Your Ref :
Our Ref : BE/106/13/NMA

Application for a non material amendment following a grant of planning permission BE/40/13/ to reduce size of extension due to the position of public drainage
23 Birdham Close, Bognor Regis, ,

DRAWING NUMBER 12092/01R1

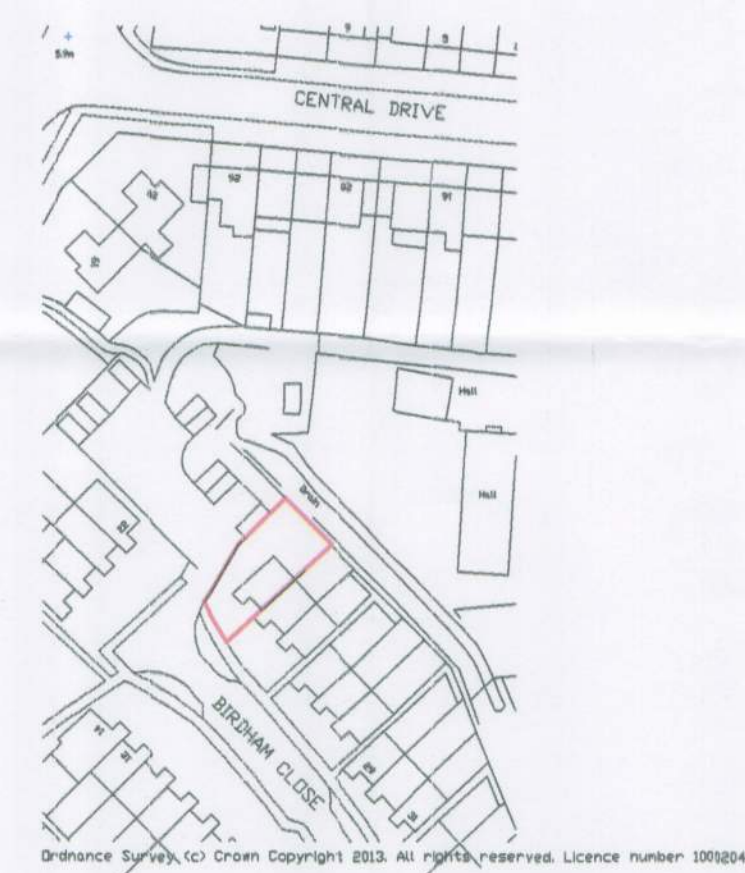
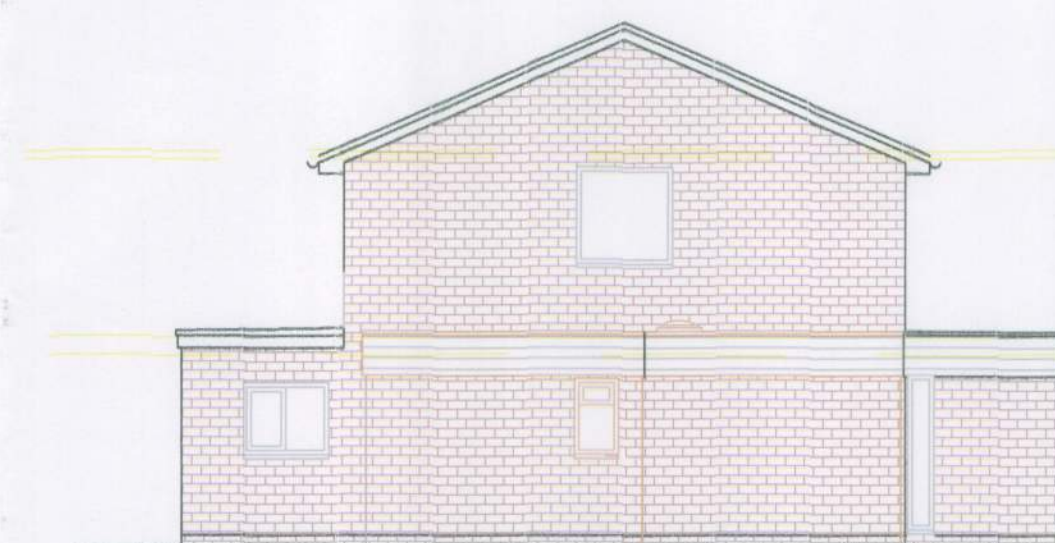
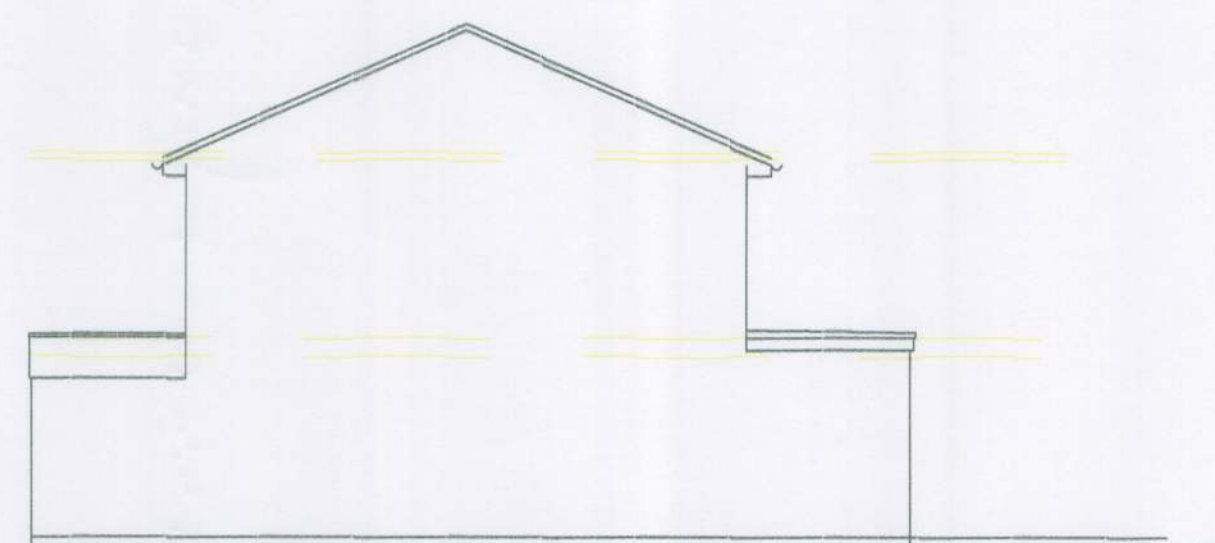
The reduction in size of the single storey extension on the side elevation of the dwelling due to the position of the public sewer can be accepted as a non-material amendment. The submitted Drg No 12092/01R1 dt 17.11.13 now becomes the approved plan for planning application BE/40/13.
